File No. D07-12-17-0162

**Subject: Technical Circulation Comments
Site Plan Control Application: 3058 Jockvale Road**

The following comments are provided in response to the submission received by the City on May 4, 2018 and deemed complete on December 19, 2017:

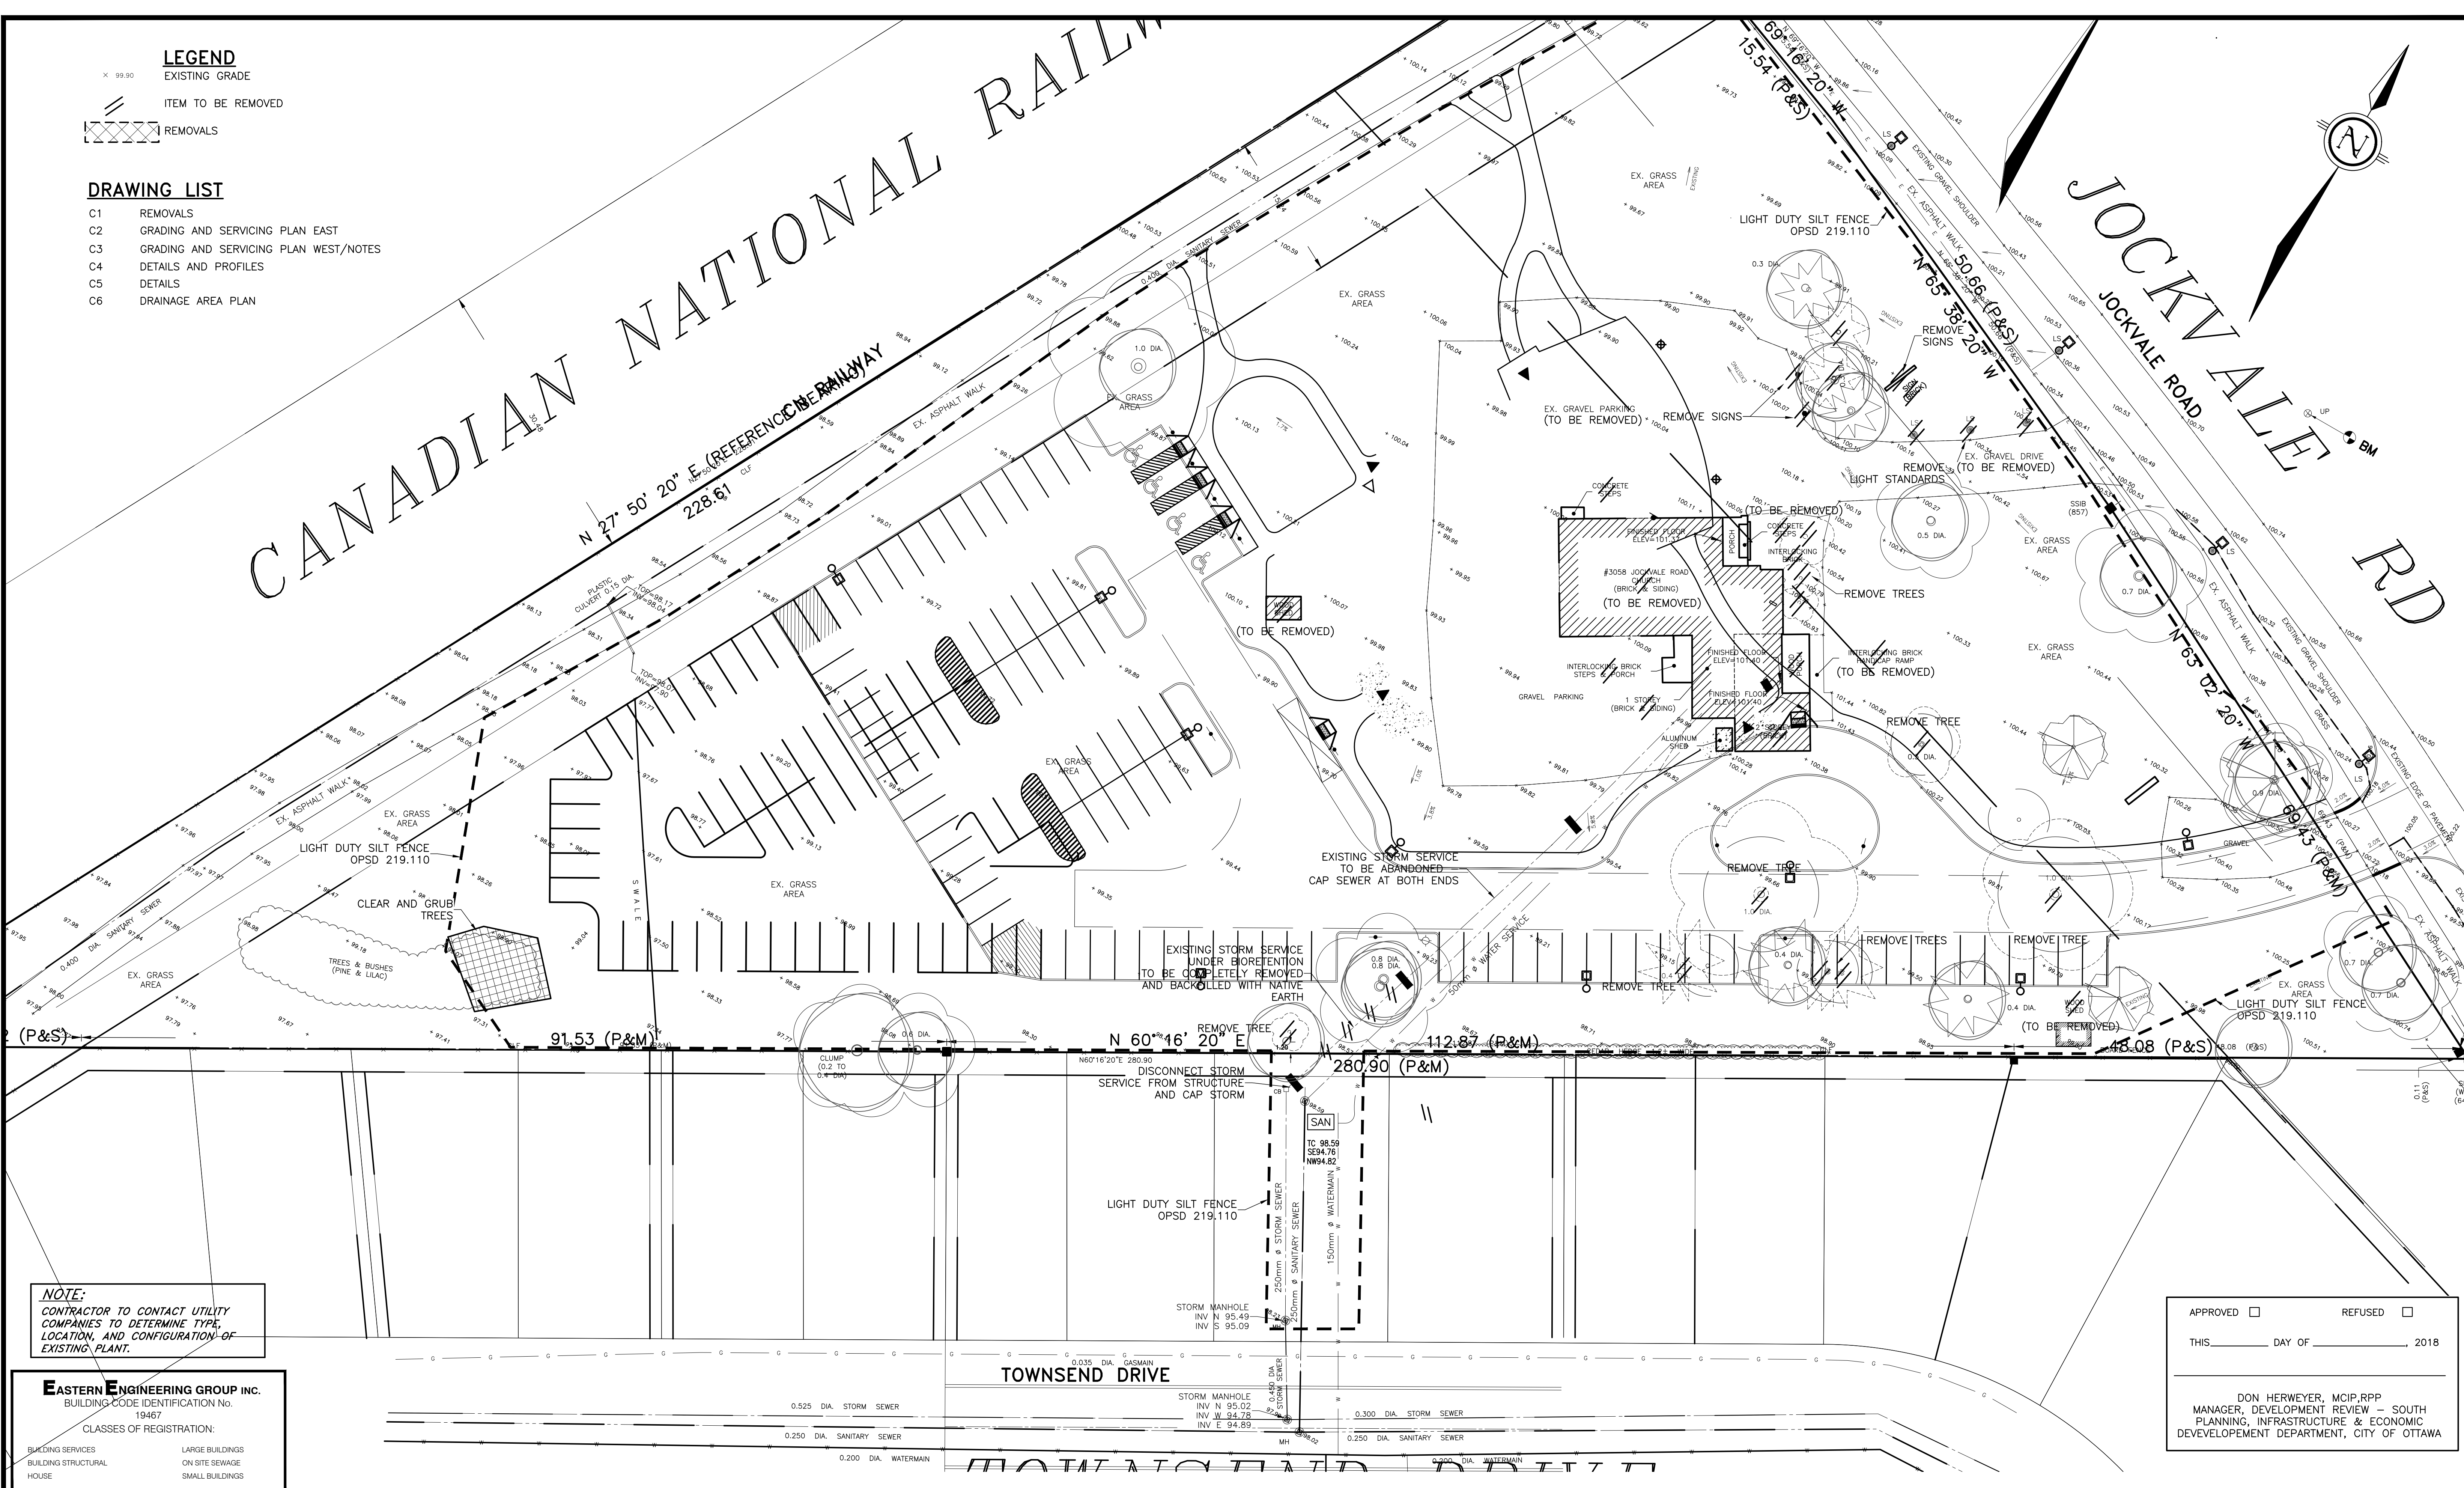
5. Provide a note that abandon storm sewer will be filled with flowable fill material as per F-4104 on the plan. **Note on C1 was added on last submission. The note added says “ABANDONMENT OF STORM SEWER AS PER CITY OF OTTAWA STANDARD TENDER DOCUMENT F-4104”. I have added “STORM SEWER TO BE FILLED WITH FLOWABLE FILL MATERIAL AS PER F-4104”. This was not on previous comments and should be have been addressed in previous comments added. F-4104 was referenced. Comment 20 did not reference the F-4104, but comment 22 did.**

DRAWING TITLE
SITE PLAN

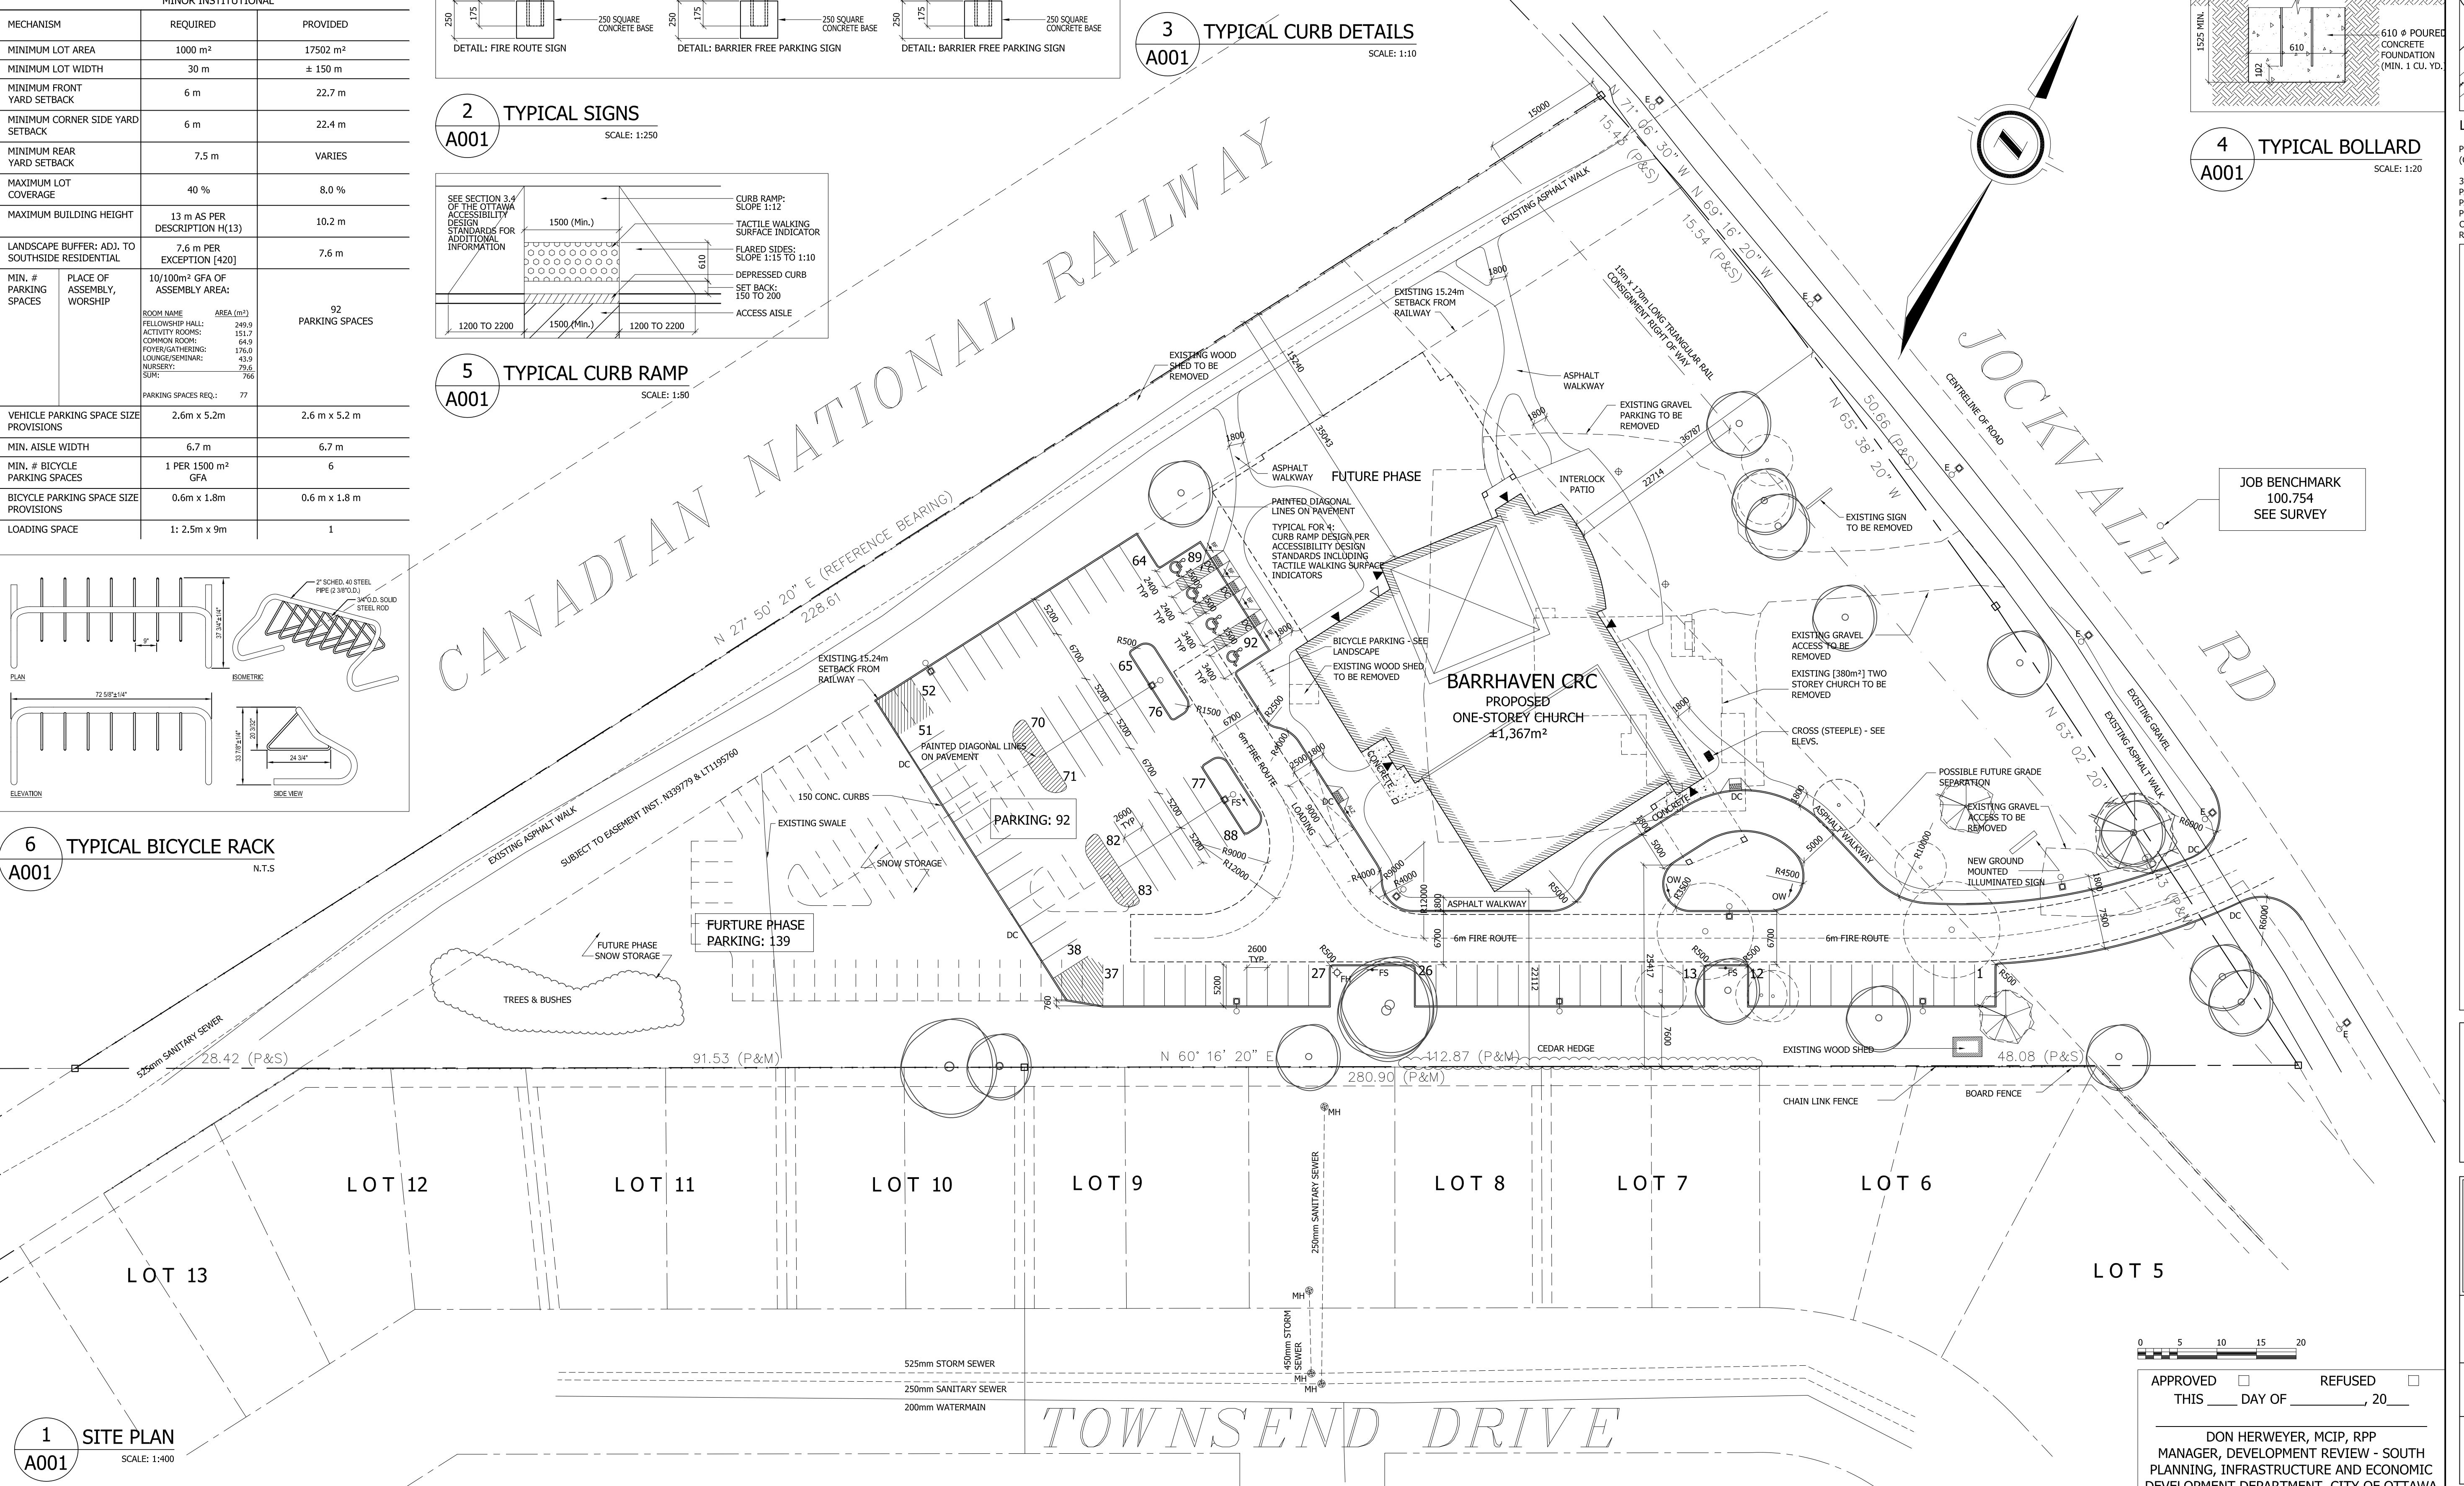
1. What is the GFA for the site? While this has been added there are discrepancies between the information provide on the site plan and the information provided in memo sent to Charles E. Sarazin on May 8, 2018 which states that the GFA is 1,368 m². Please confirm.

2. The parking rate is 10 per 100 m² of gross floor area of assembly area. There are different parking rate for different uses. Please ensure that this is correctly calculated, as there is likely opportunities to reduce the requirements. The GFA sum in the zoning table for parking requirement is 701.1 m² which is not consistent with GFA calculation mentioned in the above point.

3. Please revise the plans to ensure that the handicap parking layout conforms to the 3.66m minimum width, as per e-mail dated May8, 2018 to Charles E. Sarazin.

The Gross Floor Area is: 1251 m²

The Building Area is: 1367 m²

Both are labeled on the Site plan.

The parking rate calculation has been revised on the site plan.

The Handicap parking layout has been revised. All spaces meet the minimum required width of 3.66m
